Scoping Opinion - Gortyrähilly Wind Farm, Ballingear, Co. Cork

Ecology Office Advices - Pre-Planning / General Scoping

PPW: 6225 Gortyrhilly Wind Farm, Co. Cork and PPW: 6226 Inchamore Wind Farm, Co. Cork

From: James Dwyer <James.Dwyer@CorkCoCo.ie>
Sent: Monday 4 July 2022 13:13
To: Sean Molloy <smolloy@jodireland.com>
Subject: RE: 6225 Gortyrahilly Wind Farm Ballyvourney Co. Cork - Grid Connection & Turbine Delivery Route Drawings

**ELEVATION**  
Scale 1:500

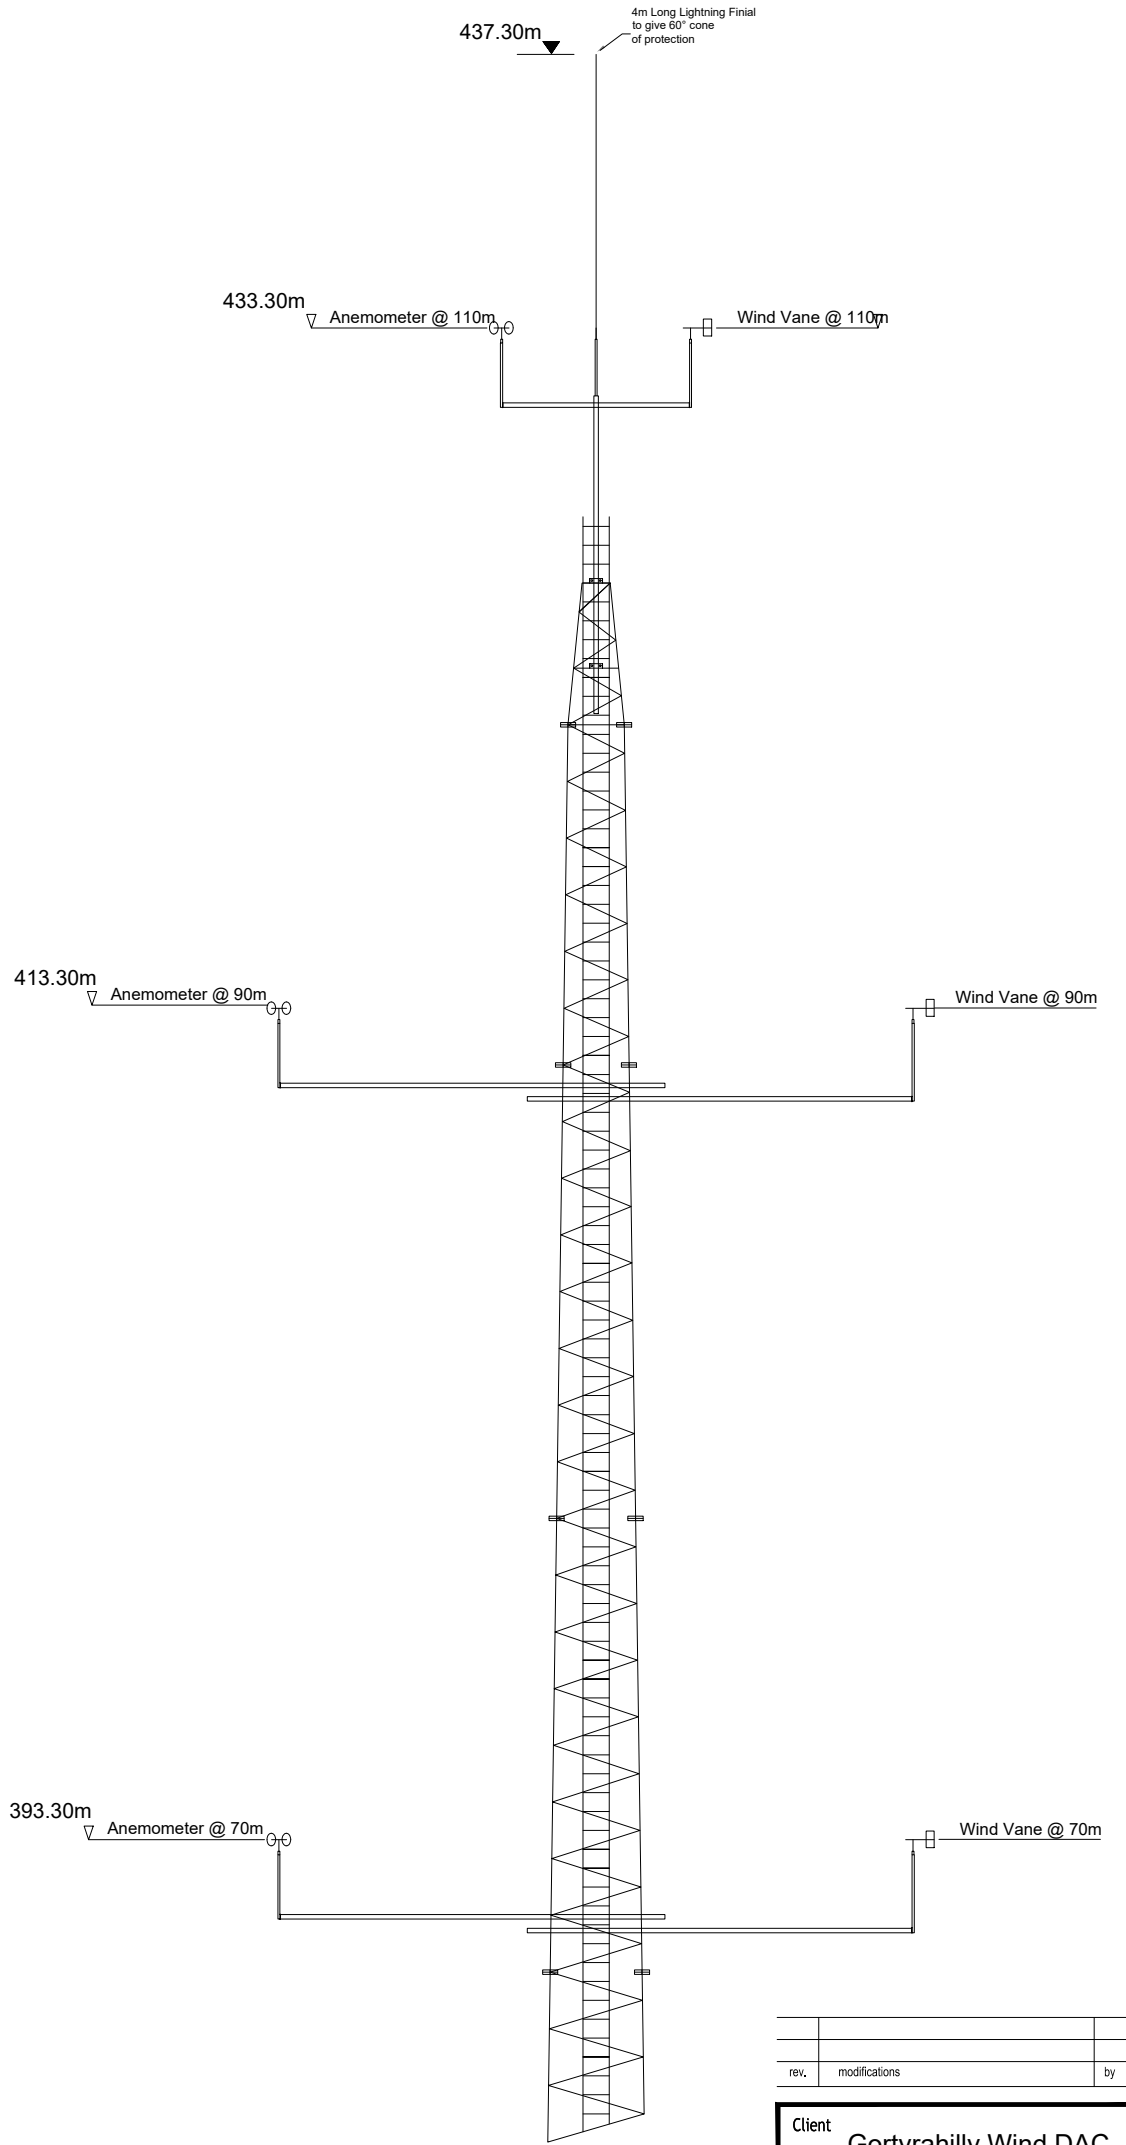
- Identify Met Mast and clarify height
- Ecology unit has identified some turbines they have concerns with. See attached comments.
- Determine grid connection and include same in application for turbines would be advisable

Title
Turbine Delivery Route
Index Map

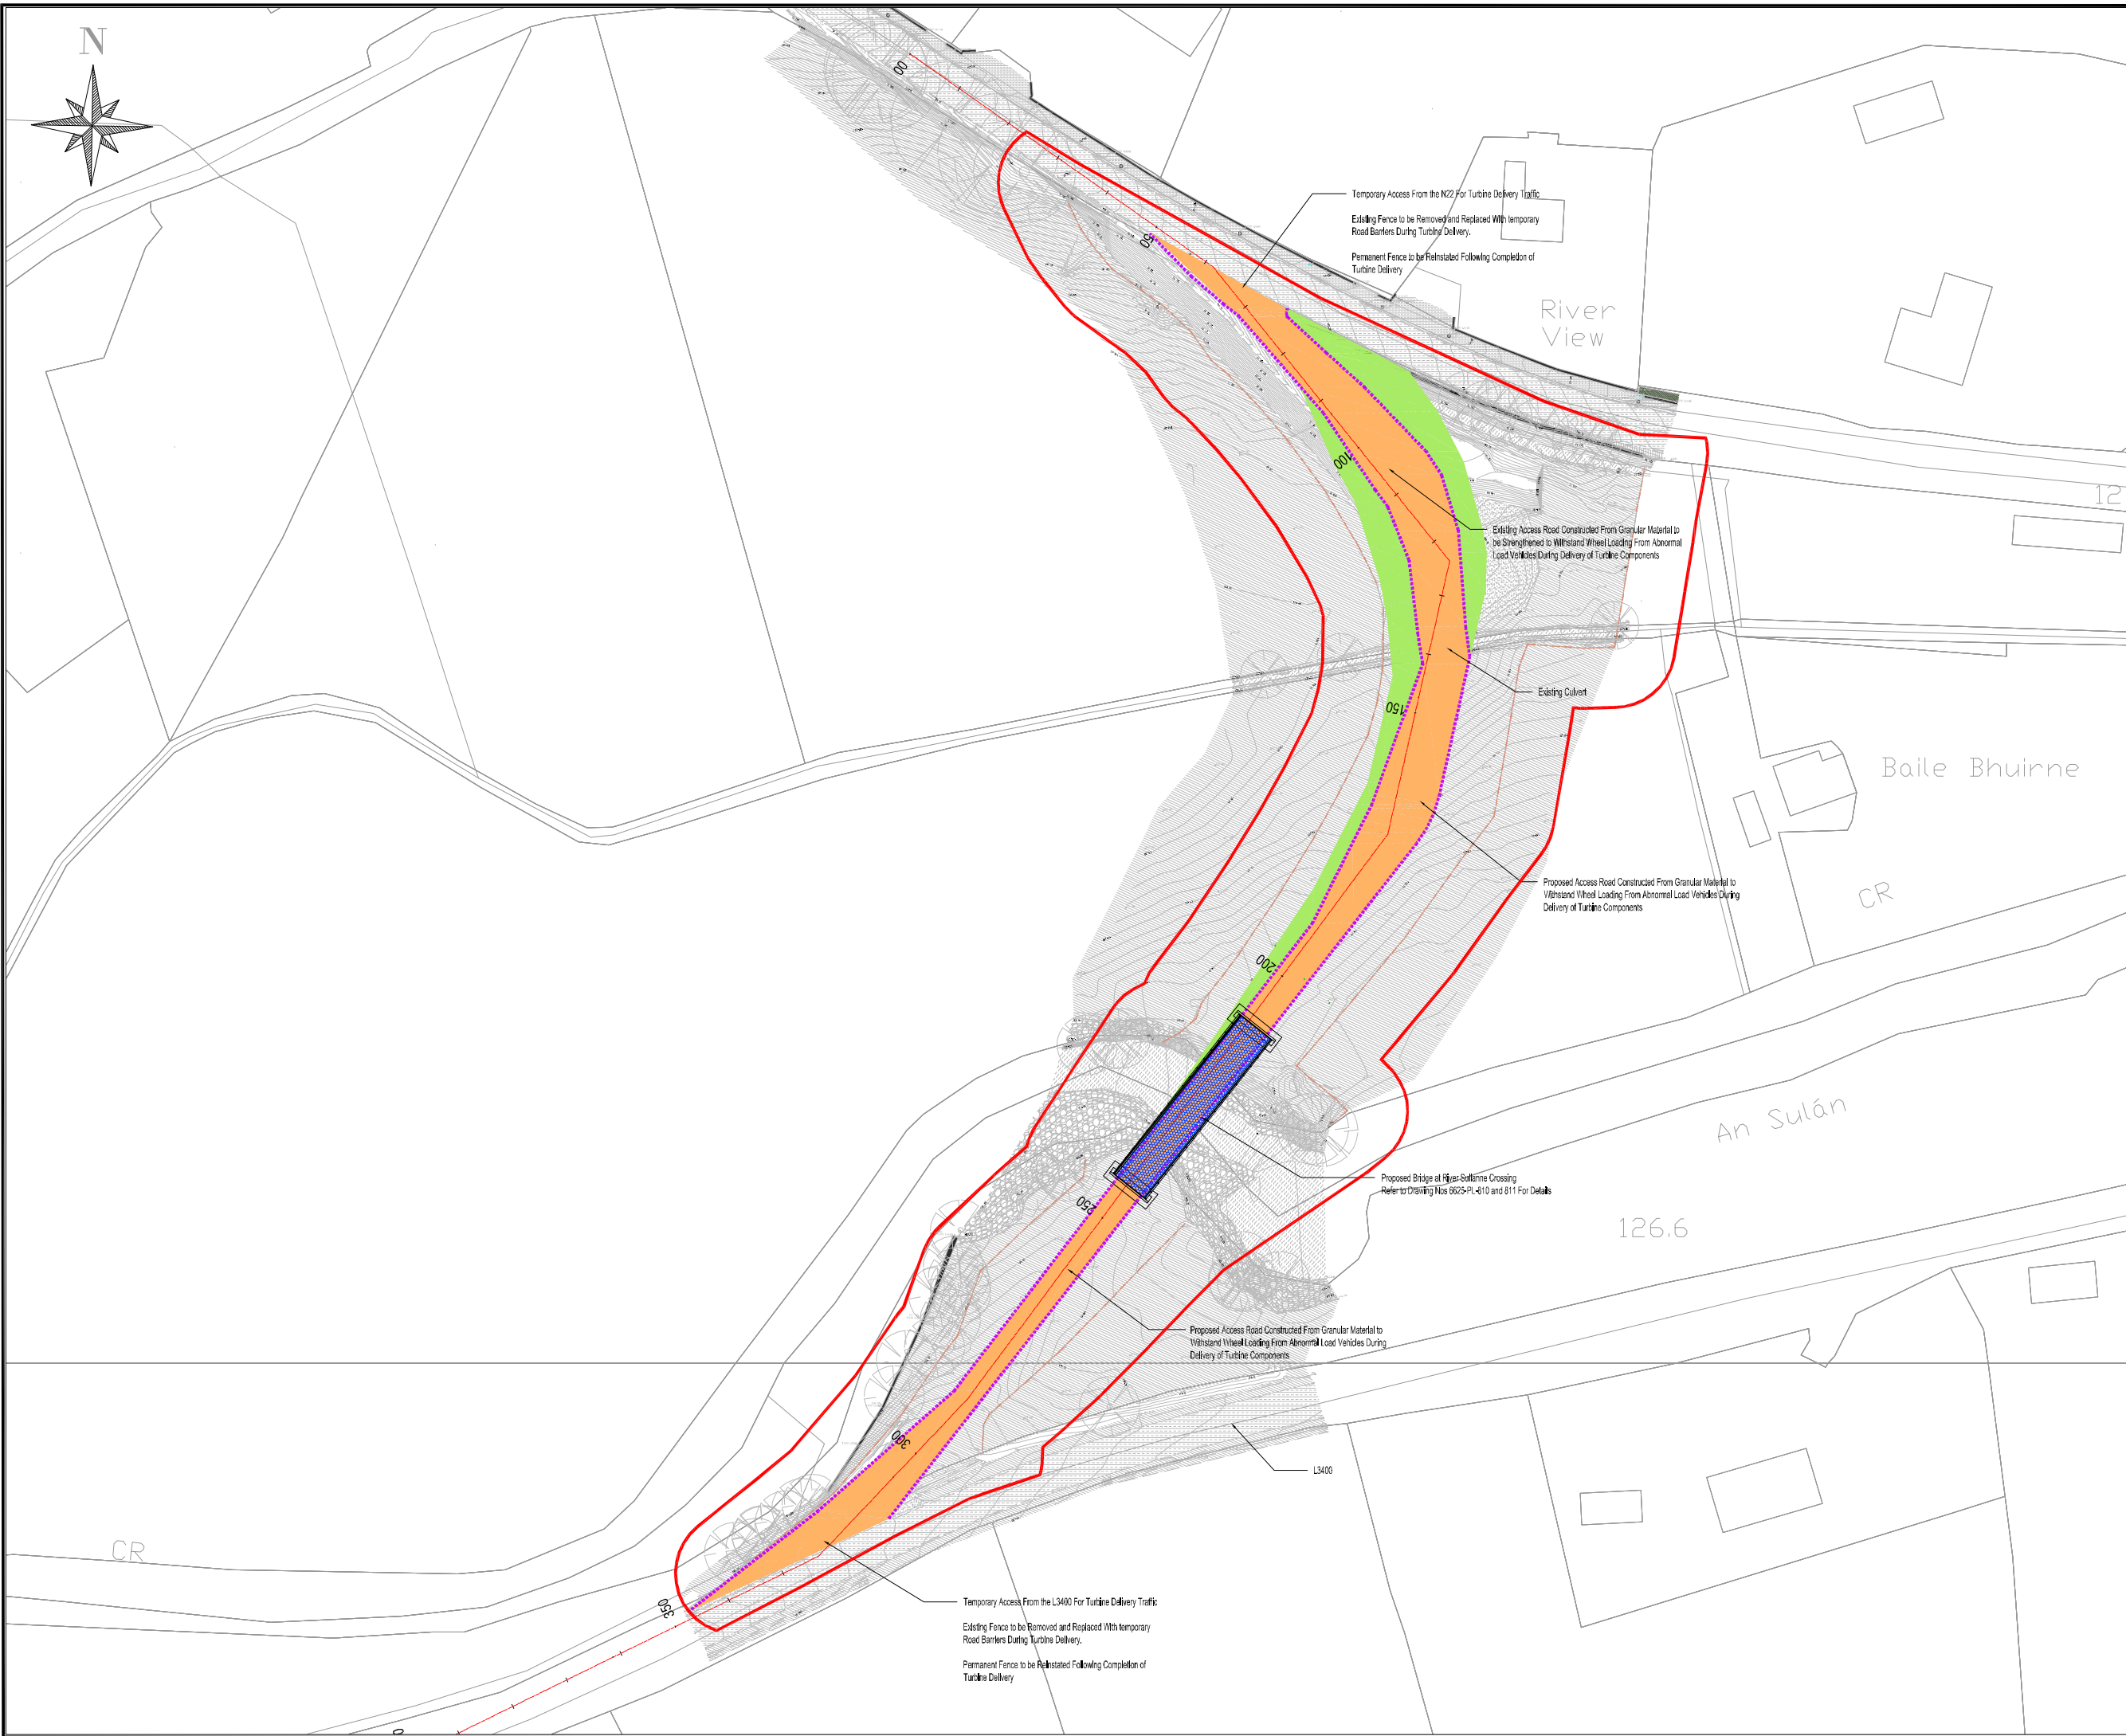
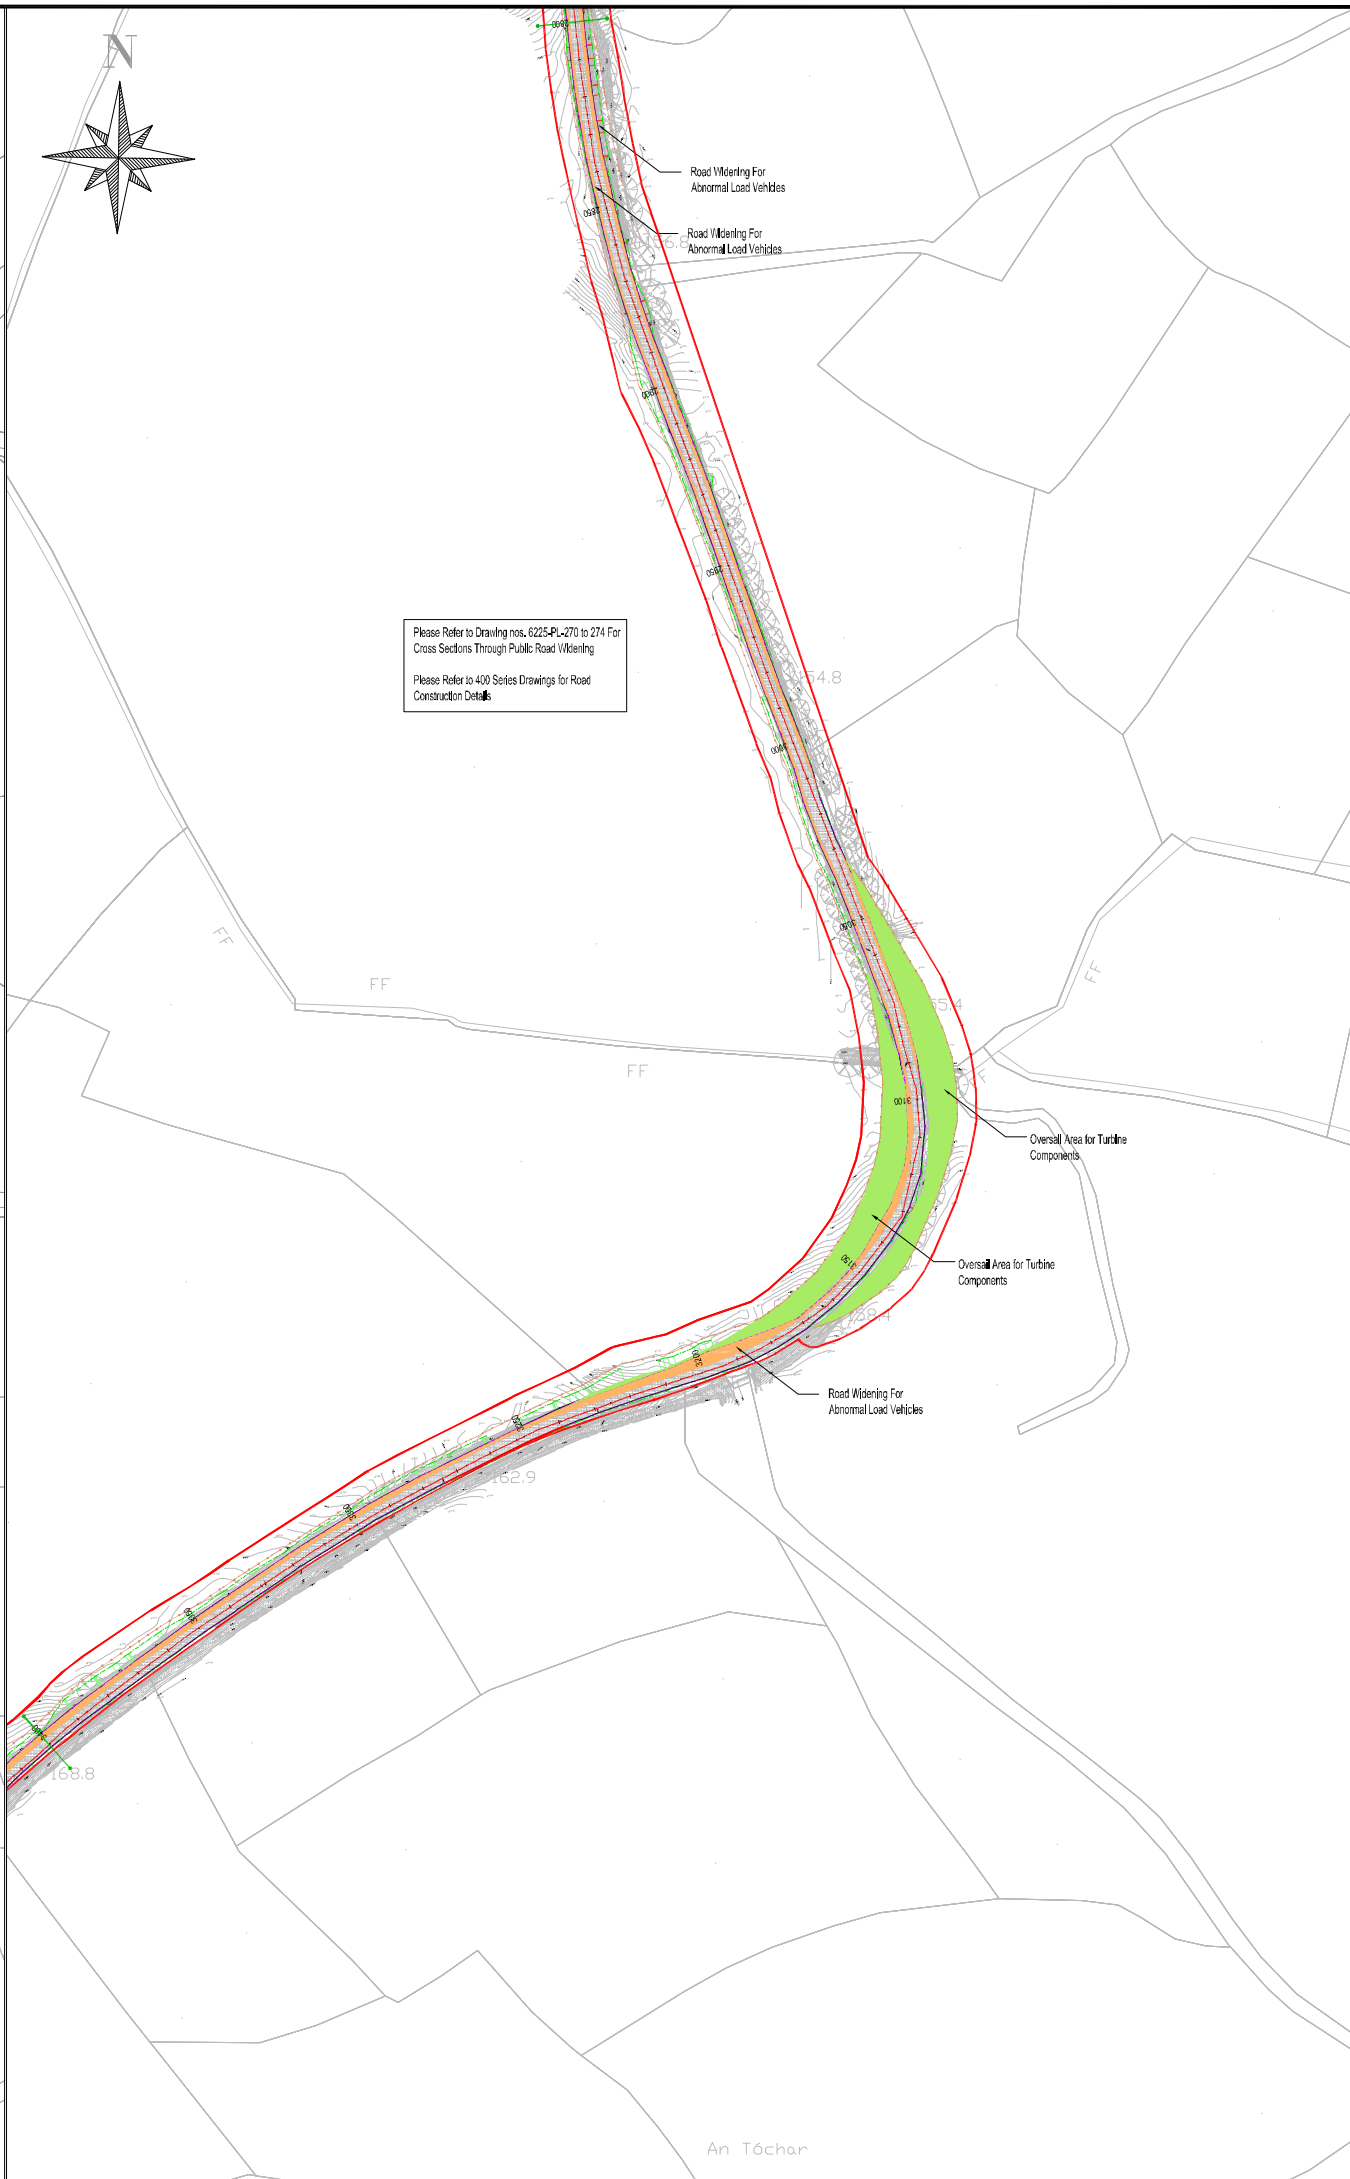
My comments on the delivery route are as follows:

- My previous comment re the junction off the N22.
- The consents for the re-installation of the temporary bridge could be difficult.
- Widening and strengthening of the local road network from the main Coolea/Ballyvourney road south will be required.
